## Appeal Decision

**Appeal Ref: APP/R5510/D/23/3333912**

**32 Dene Road, Northwood, Hillingdon, HA6 2BT**

- The appeal is made under section 78 of the Town and Country Planning Act 1990 against a refusal to grant planning permission.
- The appeal is made by Mr Kirishnathasan Thillainather against the decision of the Council of the London Borough of Hillingdon.
- The application Ref: 77349/APP/2023/2065, dated 10 July 2023, was refused by notice dated 6 September 2023.
- The development is described as: 'proposed front porch'.

## Existing & Proposed Ground Floor Plan

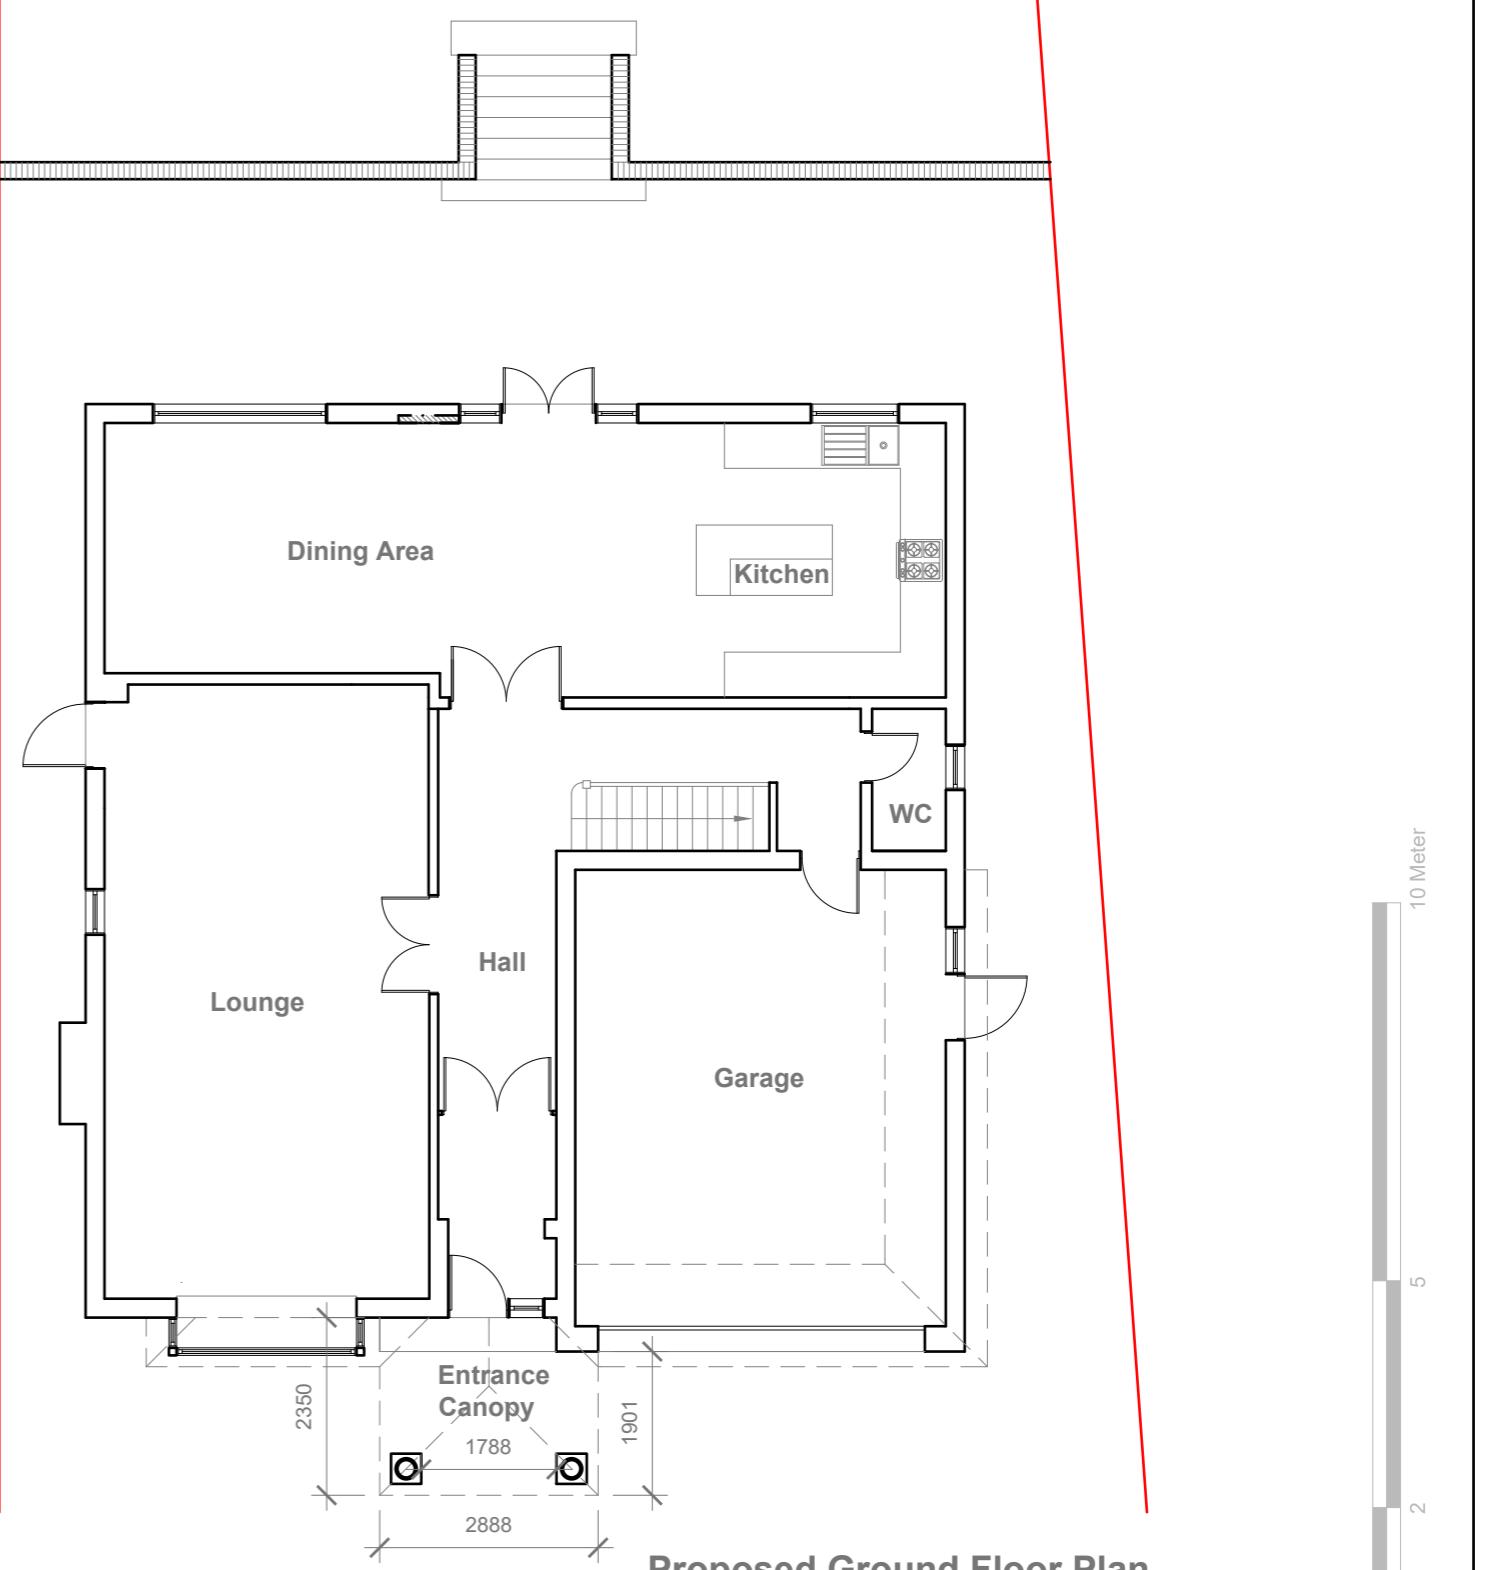
5. The porch would have a hipped roof design and an equivalent eaves height to replicate the roof structure covering the bay window and garage that would be positioned on either side of the porch. The ridge height of the porch would also be below the garage roof covering. I consider that this would ensure the porch would be of an appropriate scale and would appear subservient to the main dwelling when viewed in the street scene, whilst respecting the architectural style and character of the original building.

6. The porch projects beyond the principal elevation of the dwelling but it would not appear bulky in this context as it would be a modest structure in comparison to the much larger dwelling to which it would be attached. The porch would not appear prominent in the street scene because of the subservient design described above and due to the fact the host dwelling is set back considerably from the street.

7. The Council raises concerns regarding the two columns that would support the roof structure of the porch, citing paragraph A1.15 of HLP Part Two which states that classical columns and pediments will not be acceptable for porches unless they are a feature of the original house. However, this paragraph is part of the supporting text acting as interpretative guidance to Policy DMDH 1, but is not a part of the policy itself, and case law<sup>1</sup> dictates this carries less weight. The compliance with the policy as a whole outweighs what I consider to be a minor conflict in terms of the use of columns contrary to the guidance contained within paragraph A1.15 of the HLP Part Two.
